Re. BusConnects Belfield/Blackrock to City Centre Core Bus Corridor Scheme

Case ref. 313509

As an elected representative of the Blackrock Ward on Dún Laoghaire Rathdown County Council I wish to make the following observations in relation to the BusConnects Belfield/Blackrock application.

INSET
GEORGES AVE / FRASCATI PARK

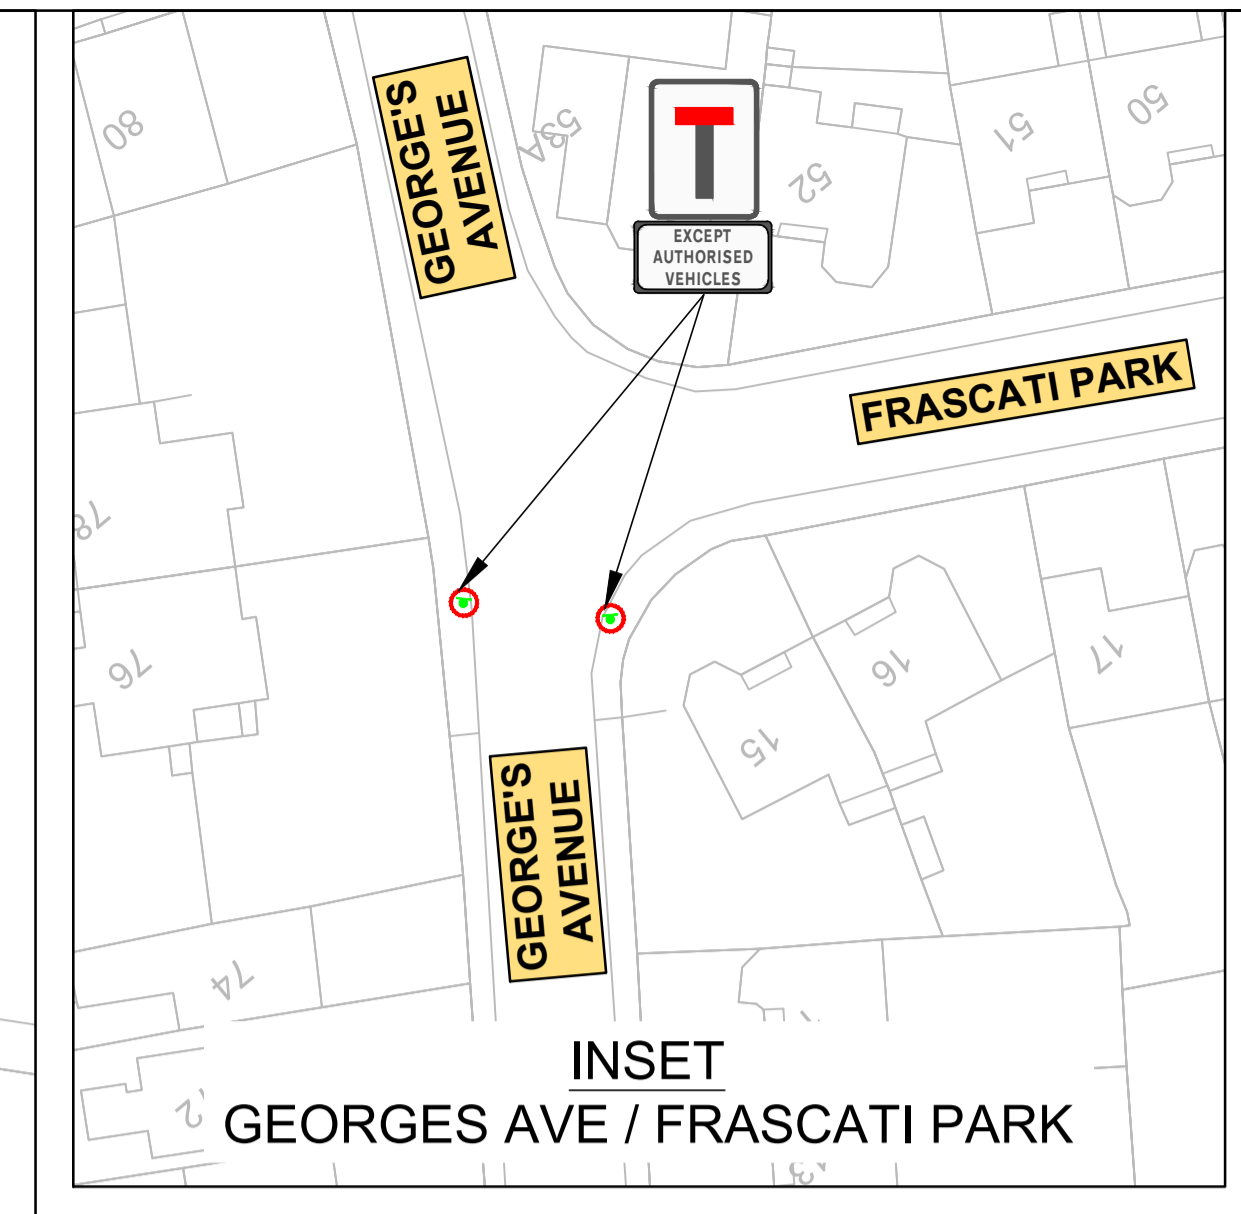
4. Proposed cul de sac George's Avenue/Frascati Park

(b) The sign erected on Frescati Road is hidden by vegetation and in my opinion is positioned in the wrong location (red X) given that the cul de sac is to take place at the location marked by the blue X, see below image

(c) There are over fifty homes on or off the section of George's Avenue/Frascati Park plus the households on Eagle Hill off this road that will be directly affected by this cul de sac. As they will not be allowed to exit onto Frascati Road it will mean that vehicles from these homes will have to do a U-turn/exit onto Frascati Park, causing unnecessary inconvenience and congestion in the narrow network of local roads.

(d) Though a provision for emergency vehicles and bin trucks has been made to exit onto Frascati Road, how are delivery trucks visiting homes on this section meant to do a U turn in what is a very narrow road?

(e) The displaced traffic from the cul de sac section and neighbouring homes will be forced to use Frascati Park or Sydney Avenue to exit onto Mount Merrion Avenue. Turning right out of either of these roads is currently difficult, hazardous, with poor sight lines.

(f) The alternative route for this displaced traffic is to use Avoca Place and Convent Road so as to access Carysfort Avenue and onwards to Blackrock. Avoca Place is barely a one carriageway road and is unsuitable for extra traffic. Carysfort NS is situated on Convent Road which is part of the NTA's Safe Route to School project and will also soon have traffic further curtailed when the School Zone initiative is implemented.

(g) Currently, when the pedestrian/cycle lights are red on Frascati Road and all the traffic is stopped, vehicles exiting from George's Avenue/Frascati Park are able to get out onto Frascati Road without impacting on pedestrians/cyclists/buses or other traffic.

(h) The reason given for the inclusion of the cul de sac is to address noise pollution concerns resulting from traffic modelling projections, to me this is a spurious reason.

(i) Local residents are being unnecessarily discommoded by this cul de sac proposal, which I believe is neither warranted nor of value. I would request that it be omitted from the scheme.
